Tel: 01903 737756
Email: planning@arun.gov.uk
www.arun.gov.uk/planning
Please ask for: Jonny Cooper
Email: jonny.cooper@arun.gov.uk
Telephone: 01903 737532
Our Ref: WA/87/25/PDH
Your Ref:
Date: 16th October 2025

Prior Notification for a Permitted Development (Householder)

Development: Notification under extended permitted development rights for a single storey rear extension measuring 8m from beyond the rear wall of the original dwelling house, with a maximum height of 3m and an eaves height of 3m.
Location: The Greenway West Walberton Lane Walberton BN18 0QS

Proposed Extension and Alterations
at The Green Way, West Walberton Lane, Walberton
for Mr and Mrs J Devenish
Drawing PNA01a October 2025 Scale 1:100 @ A3
Planning Drawing - Proposed Ground Floor Plan & NE Elevation

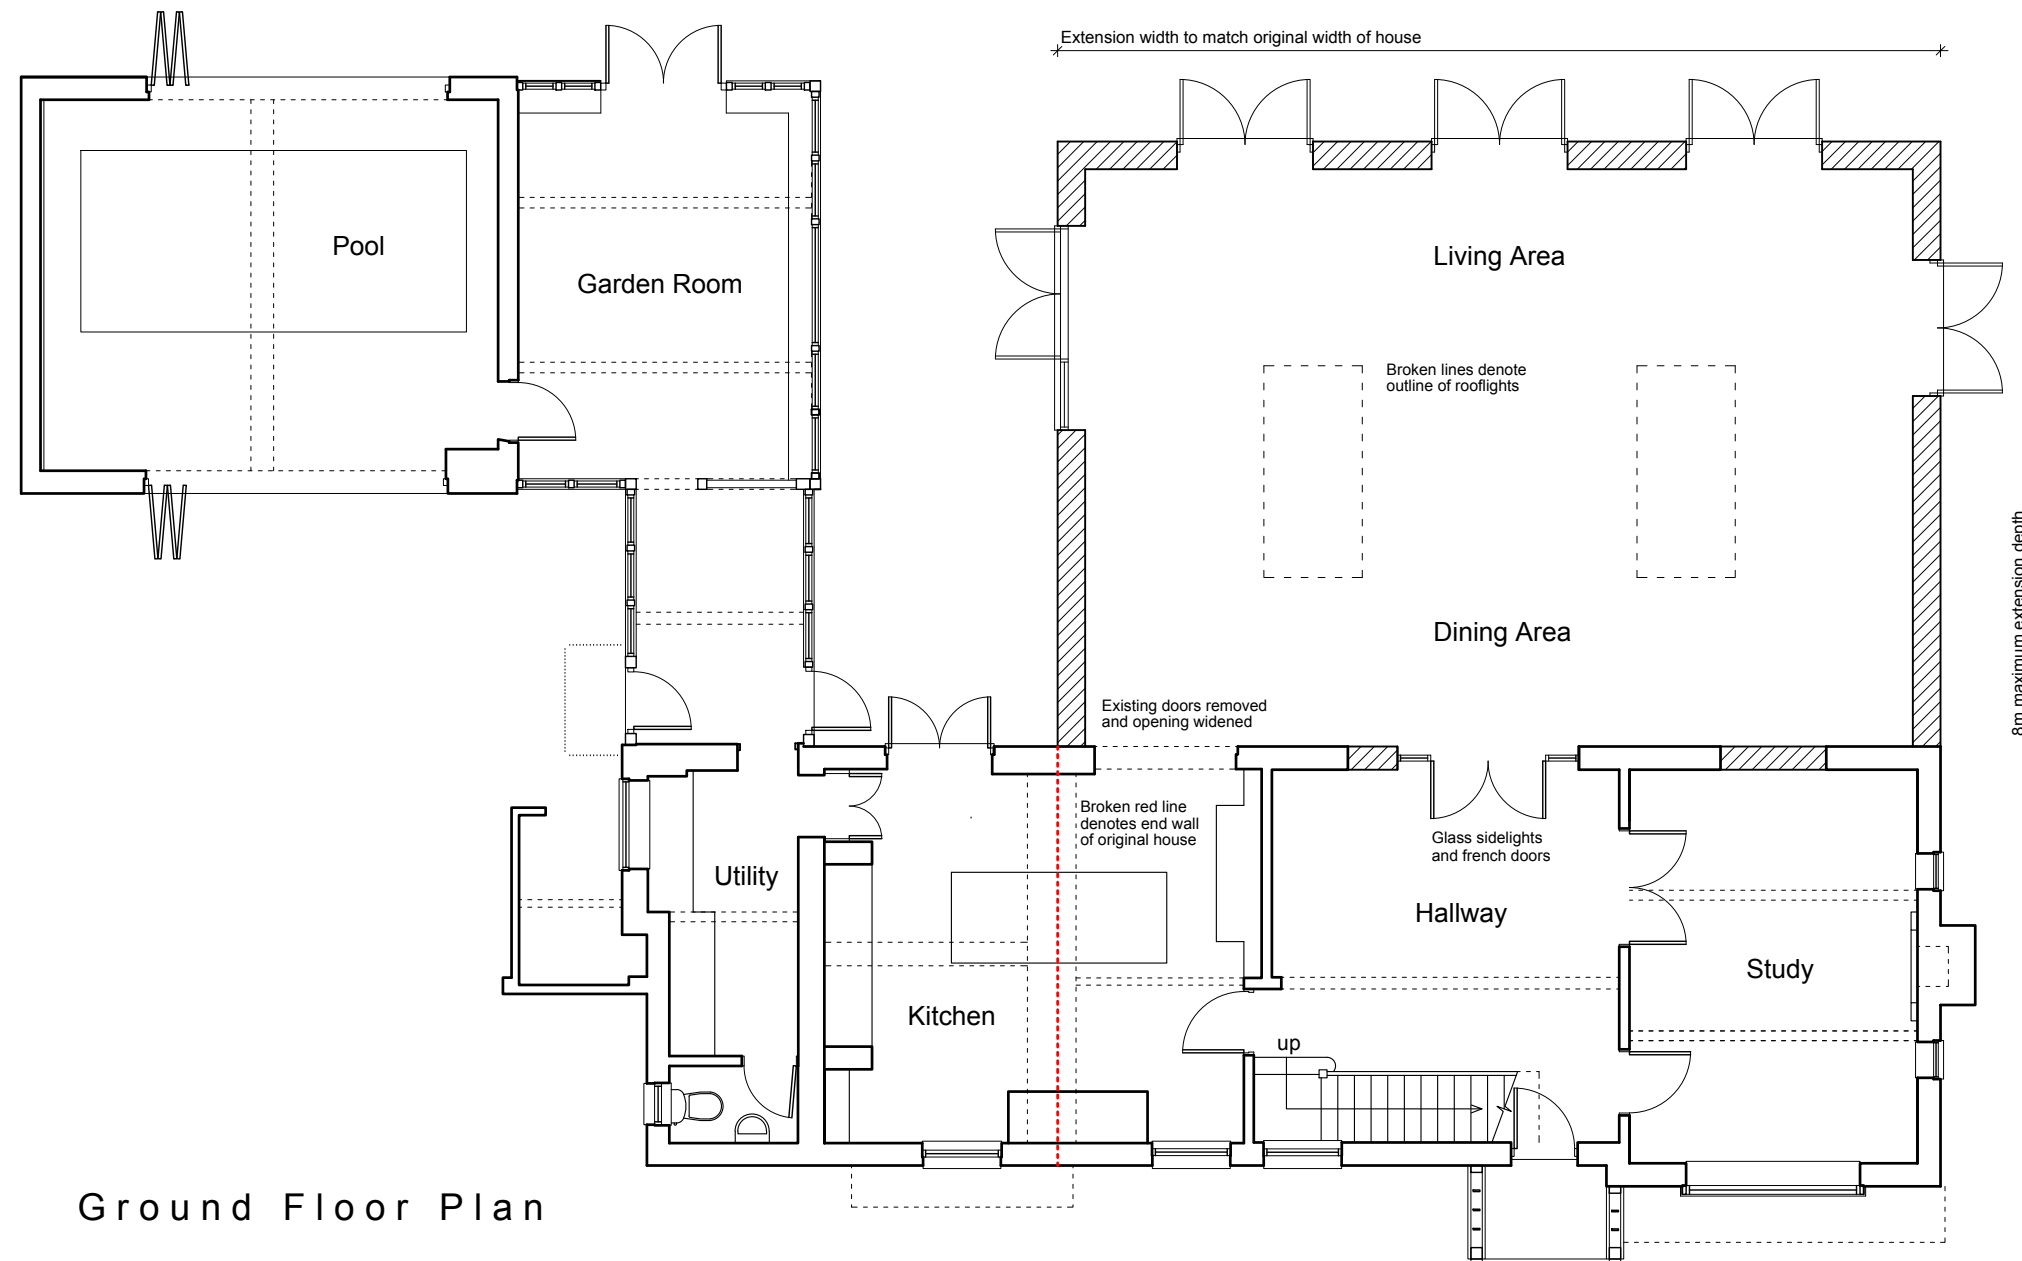
Part A.1 (D) of Schedule 2, Part 1, Class A states an application will not be permitted if "the height of the eaves of the part of the dwellinghouse enlarged, improved or altered would exceed the height of the eaves of the existing dwellinghouse." The eaves of the proposed extension exceed the height of the eaves on the garden room / pool. Please either amend your plans or confirm you are happy for the application to be withdrawn and refunded.
